Building Inspections - 1268 Westbrook- Tate House Steps Permitting FAST TRACK

From: Jeanie Bourke
To: Mark Sengelmann
Date: 6/5/2015 10:14 AM
Subject: 1268 Westbrook- Tate House Steps Permitting FAST TRACK
CC: buildinginspections@portlandmaine.gov

Temporary Stair Section
 1/2" = 1'-0" 8.5x11 output

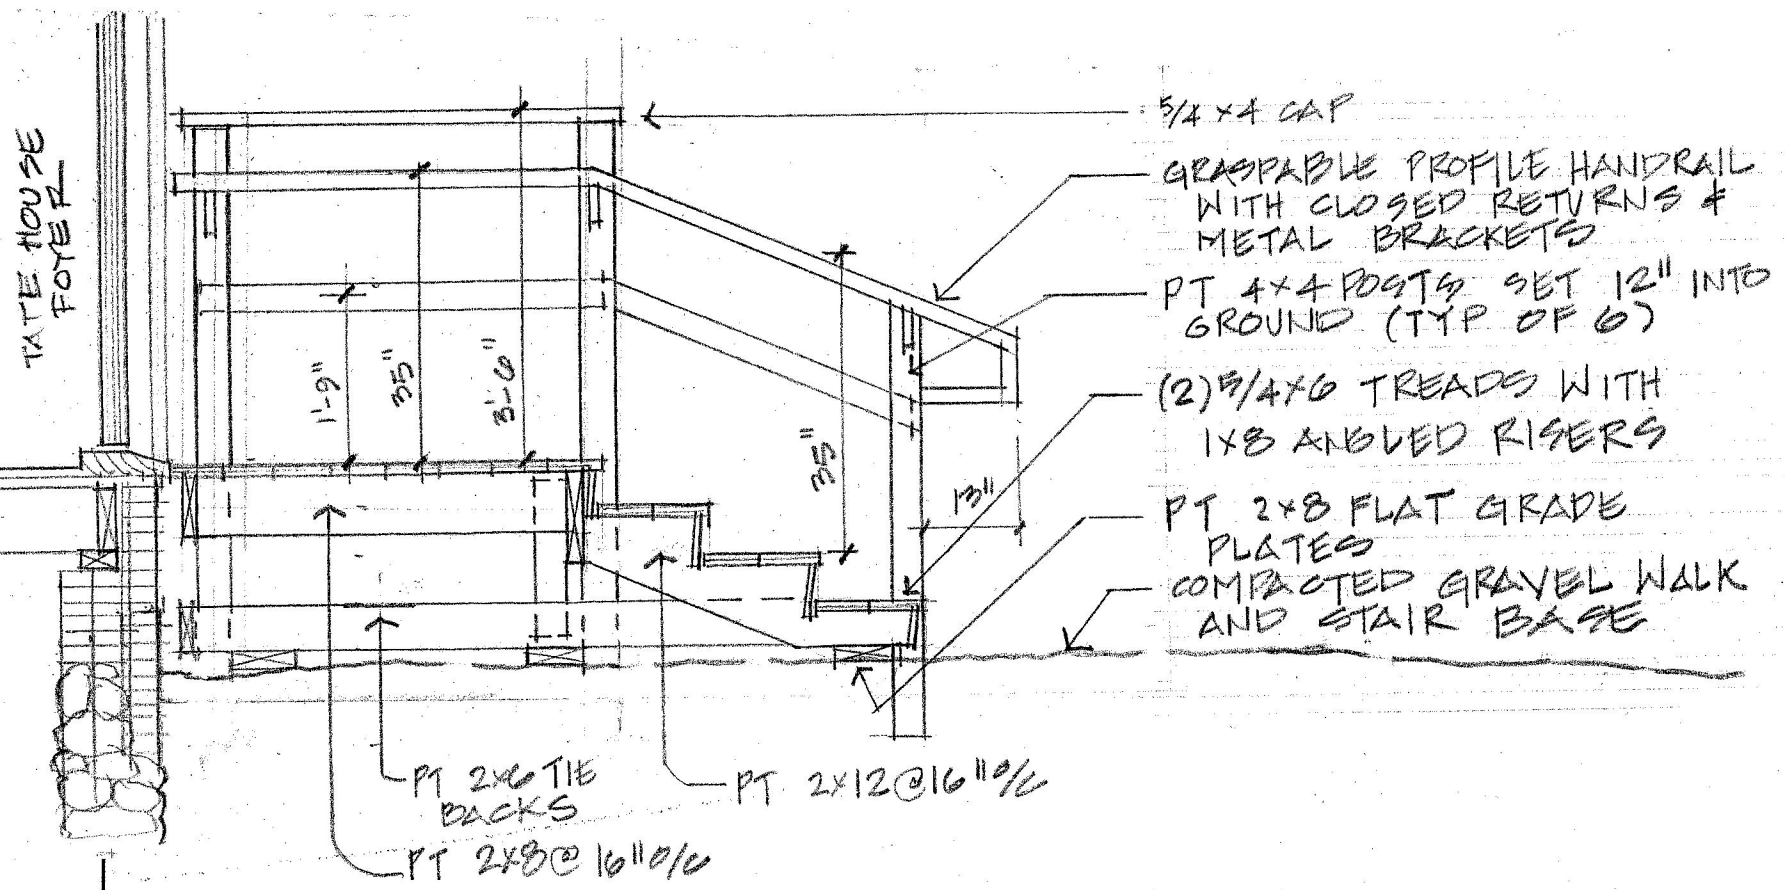
I will consider approving this to be Fast Track, pending fire department acceptance, I will send them the plans. In addition, you will need to provide a section detail of the stair including framing details.

Please include details for the stair construction per Ch. 10 including accessible requirements, profile and handrail extension/returns.

Thanks for working closely with me on this fast track project.
Please find attached the framing section that you requested:
